## City of Albuquerque

RE: REVISED GRADING & DRAINAGE PLAN OF FIRE MARSHALL'S OFFICE,  
QUINCY STREET, NE RECEIVED DECEMBER 10, 1986 FOR CERTIFICATE  
OF OCCUPANCY APPROVAL (H-17/D30)

RE: GRADING AND DRAINAGE PLAN OF FIRE MARSHALL'S OFFICE  
QUINCY STREET, NE (H-17/D30)

GRADING AND DRAINAGE PLAN
FIRE MARSHALL'S OFFICE

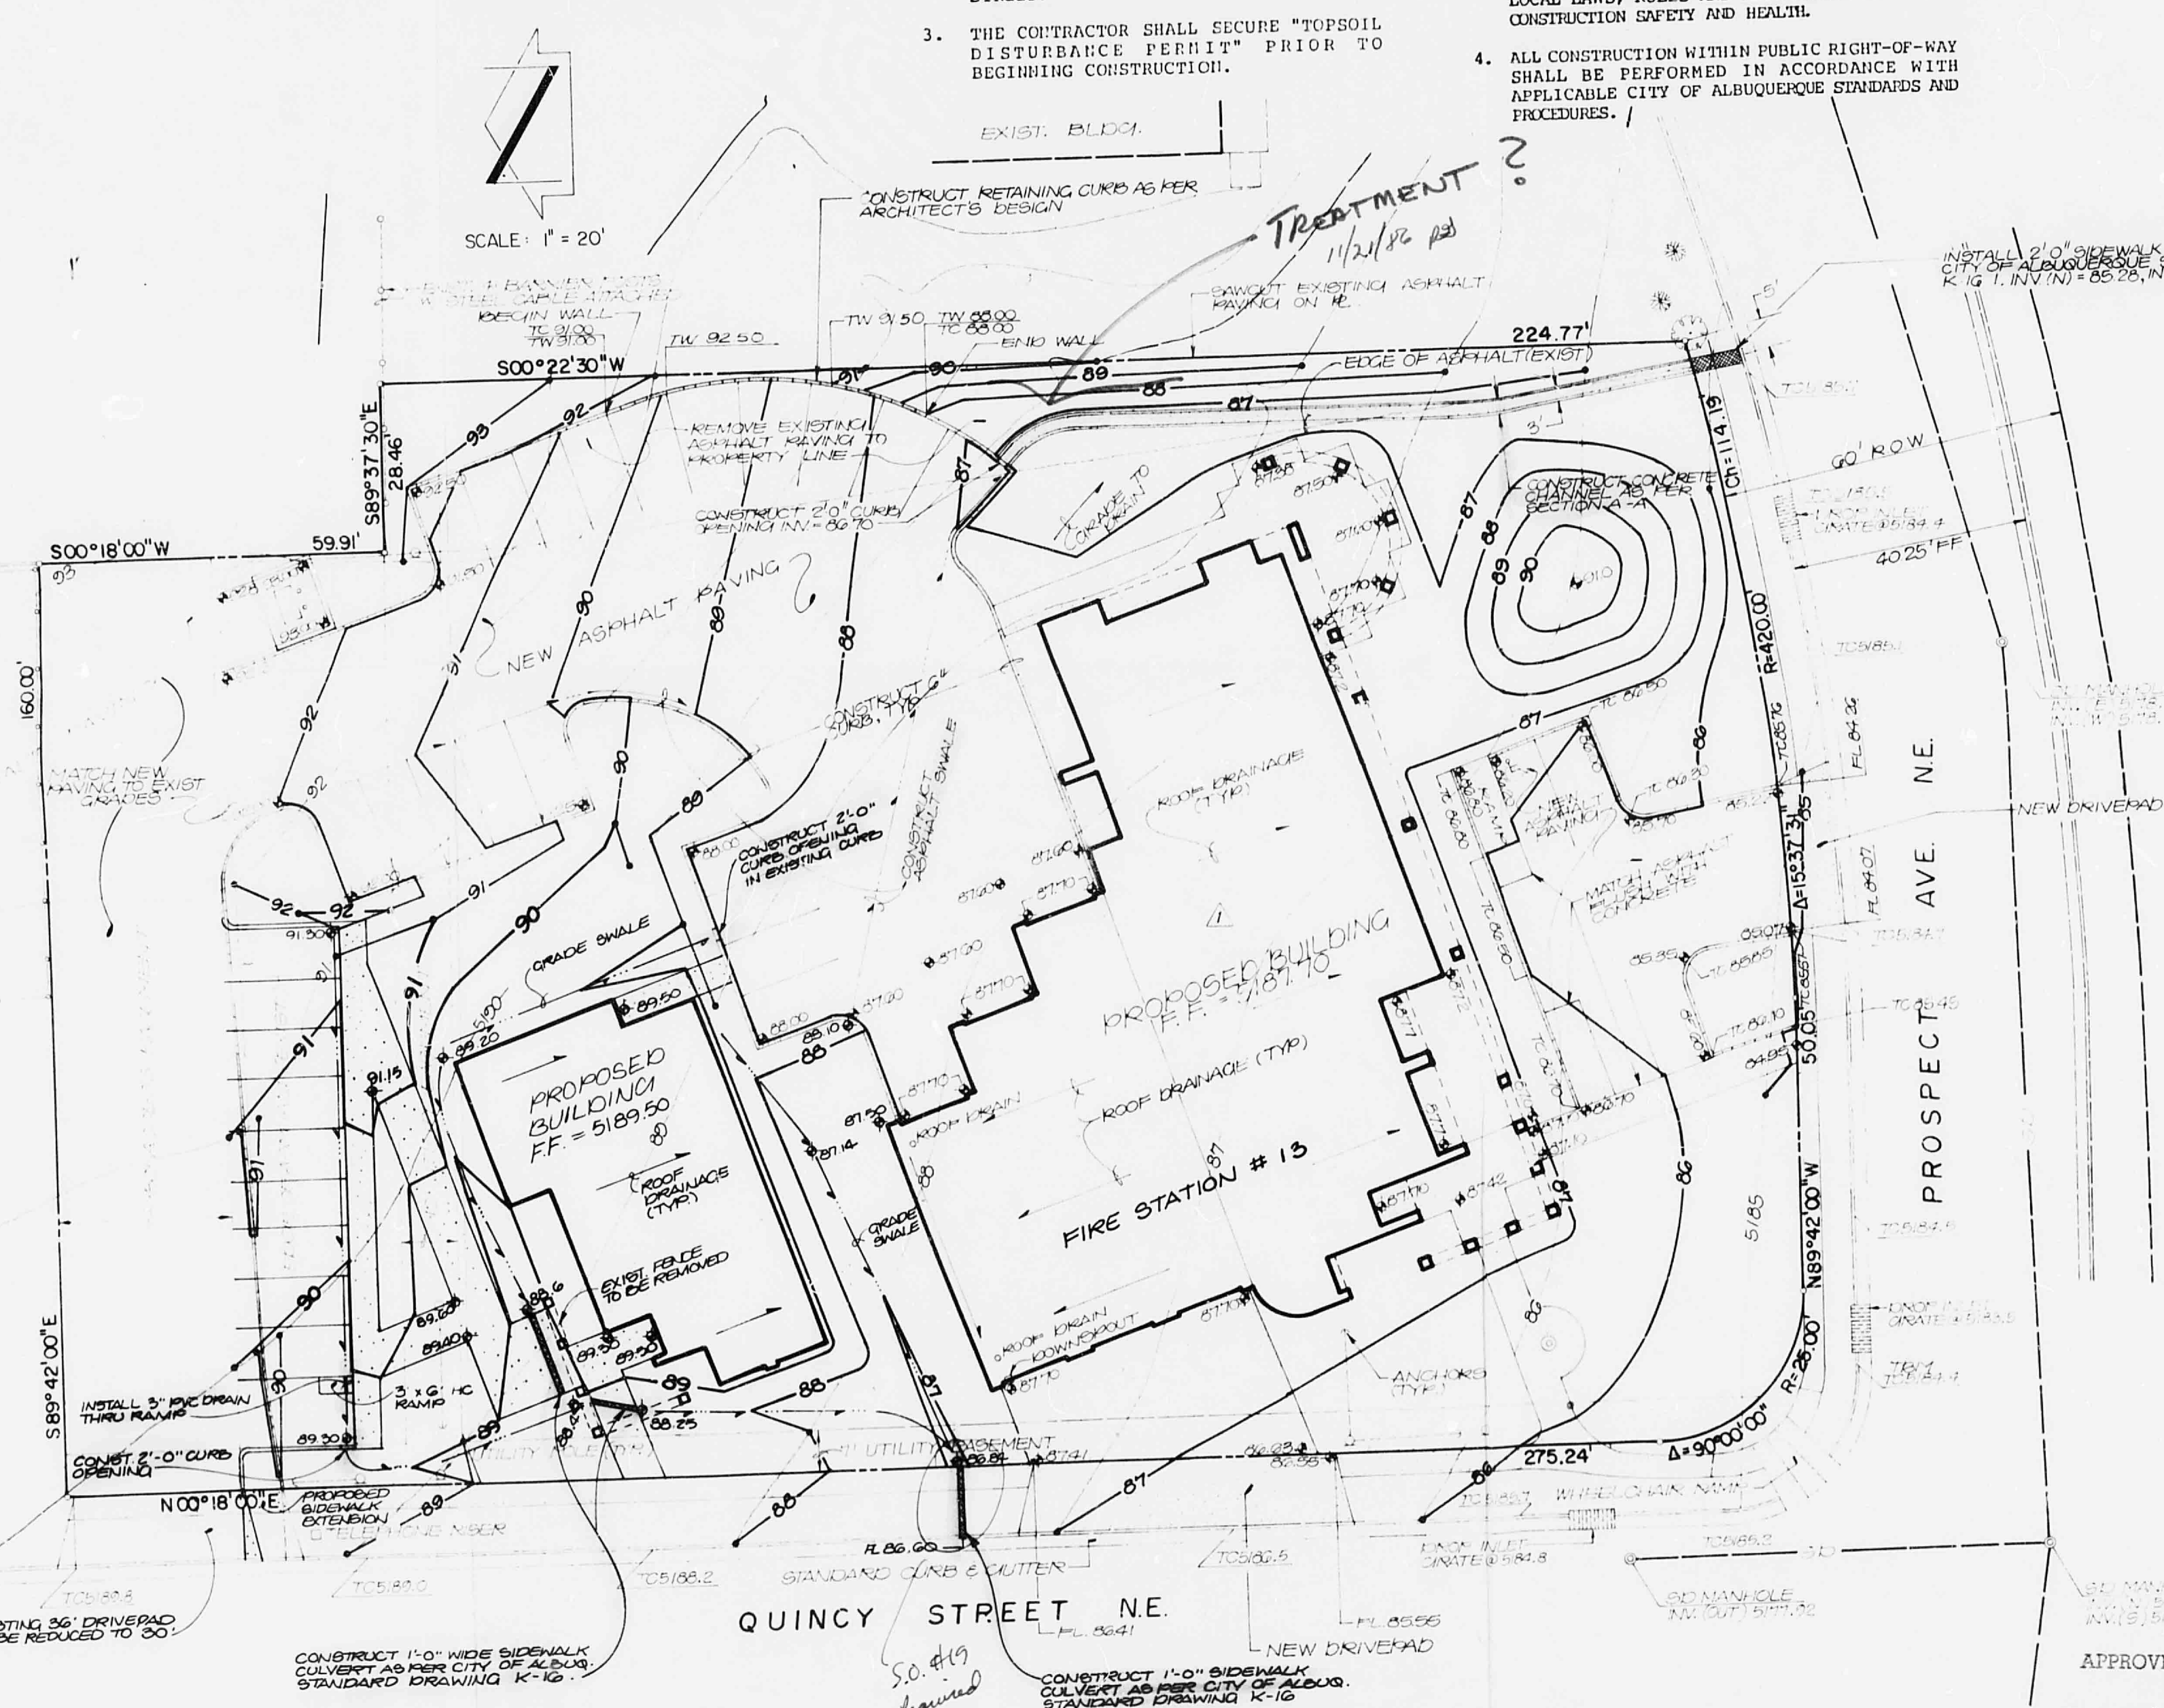
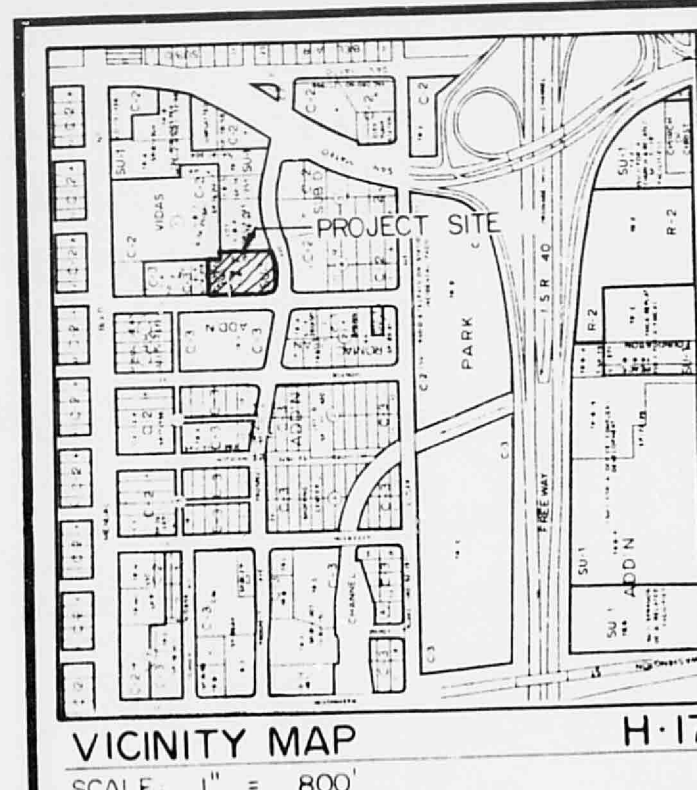
It has been brought to my attention by our Drainage Inspector that your approved Grading and Drainage Plan, dated June 9, 1986, failed to identify slope treatment along the south east corner of the project site. A drainage complaint was made by the adjacent property owner since the unprotected slope has been eroding and undercutting the adjacent asphalt. A field inspection made November 21, 1986 confirmed this.

Prior to Certificate of Occupancy approval by Hydrology for outstanding Building Permits on the referenced project site, some type of permanent slope treatment must be specified and constructed. Provide this office with a revised Grading and Drainage Plan, showing the required treatment.

The revision received December 10, 1986, to the approved Grading and Drainage Plan requiring curb along the east property line, and addition of a concrete trough is approved. This construction will eliminate off-site flows from damaging the slope and undercutting of the asphalt as previously identified.
